## PLANNING CONSULTATION RESPONSE

<b>Application No</b>	2025/0908
<b>Proposal</b>	Re-engineering and Restoration of Yew Tree Quarry through the importation of non hazardous Excavated Soil Materials
<b>Address</b>	Stairfoot Brickworks, Wombwell Lane, Stairfoot, Barnsley, S70 3NS
<b>Date of Consultation Reply</b>	27/03/2026
<b>Consultee</b>	Katie Lawrence, Planning Ecologist

C181397-01

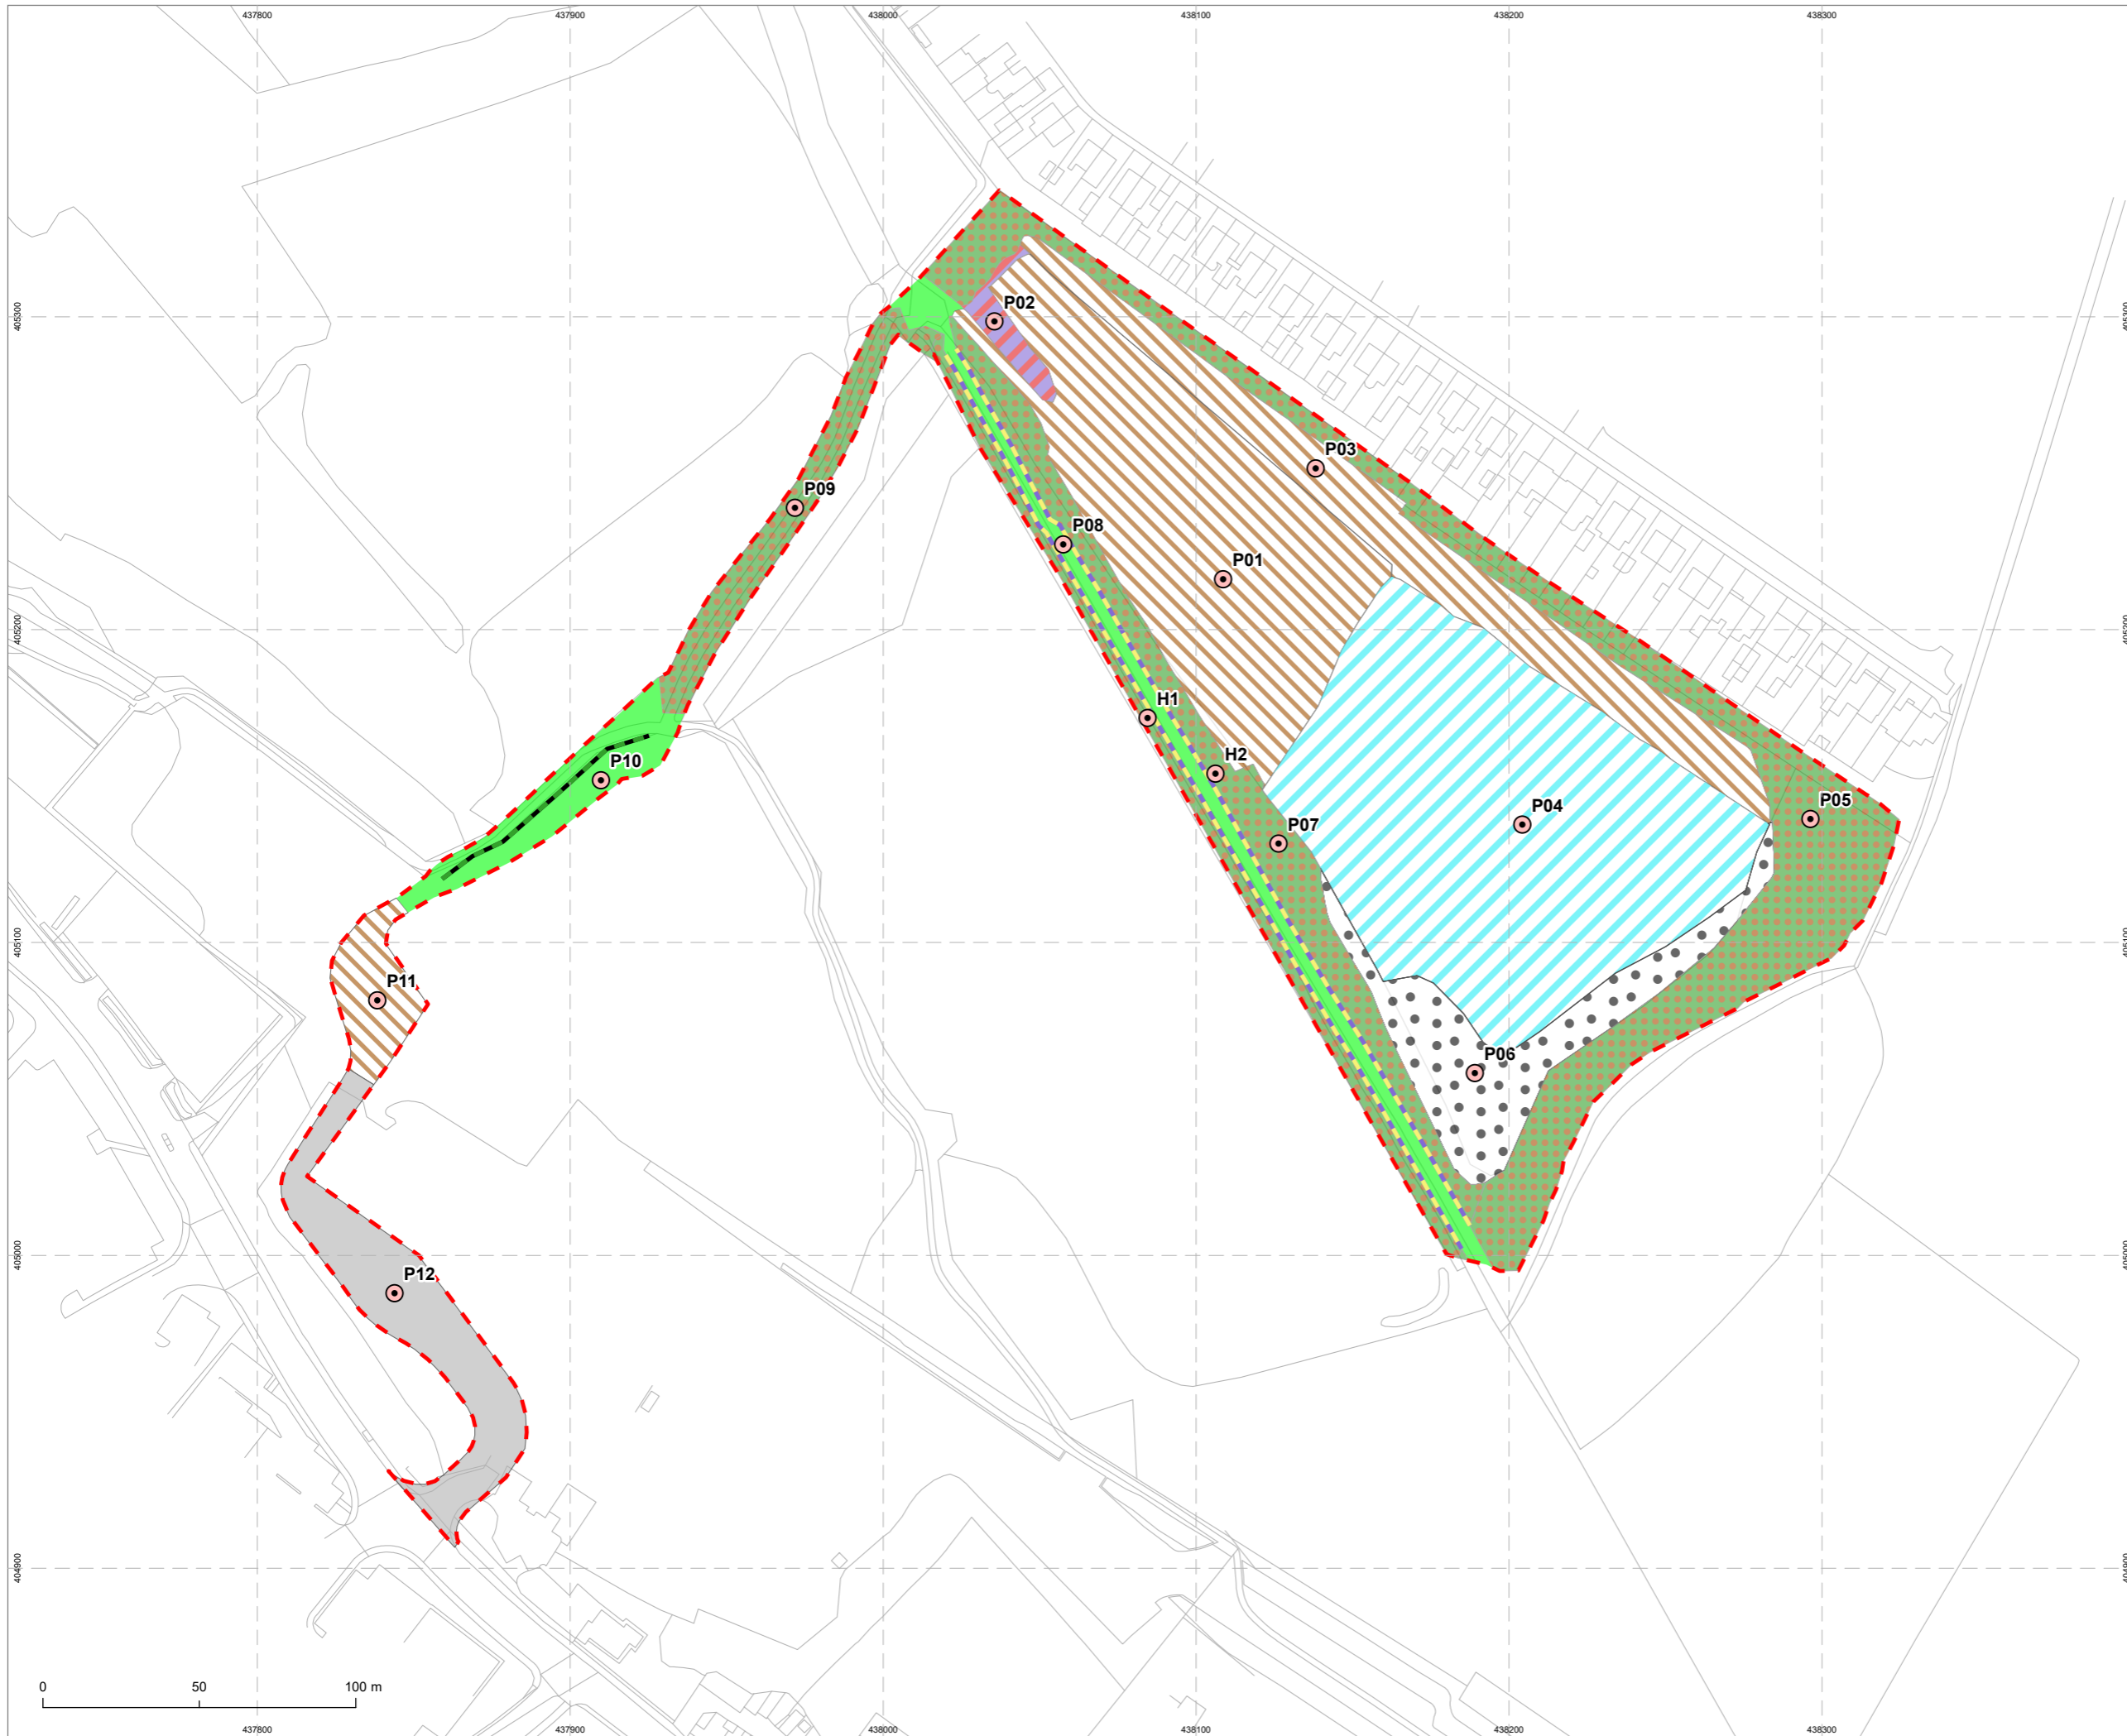
- The baseline habitat map within the PEA now includes other neutral grassland (ONG) in association with proposed access track, with this previously being mapped as a lower distinctiveness habitat, modified grassland; however, section 5.4.5 of the report still describes this habitat as modified grassland. As the biodiversity metric, which supports the application hasn't been updated, ONG is not included within the baseline tab and should be updated accordingly.

- As discussed in my previous response, Open Mosaic Habitat (OMH) is known to occur to the south of the site where access is proposed. Section 5.4.4 of the report notes the presence of OMH on site; however, this is not mapped within the baseline habitat map, and again not input into the baseline habitat tab of the metric.

- Similarly, the PEA states that the pond on site is likely to represent priority habitat due to the known presence of grass snake; again, the metric has not been updated to include a priority pond within the baseline tab.

- As noted within comments relating to the PEA, some baseline habitats noted on site are not concurrent with those included within the baseline tab of the metric and therefore the overall net change indicated is not considered to be accurate. An updated BNG assessment and metric should be submitted in support of the application to agree the baseline value of habitats prior to permission being granted.

- It is noted that sections to the south, where access is proposed, are mapped as tall ruderal vegetation and modified grassland. These areas were surveyed in relation to a separate planning application (ref: 2024/0373) for a glass recycling centre. I undertook a site visit in July 2024 when reviewing this application, following which it was agreed that areas of the site (including parts of the access route which falls within this applications boundary) met the JNCC definition of OMH, with annual species, ruderals, inundation species and areas of open grassland. Reference should be made to the ecology report submitted in relation to this application and amendments made, where necessary. As the baseline survey was undertaken at a suboptimal time within the year (February 2025), this is likely to be the cause of the downgrading of these habitats. The PEA has confirmed the presence of OMH on site, but this habitat is not mapped within the associated baseline habitat map and should be input into the baseline tab of the metric.
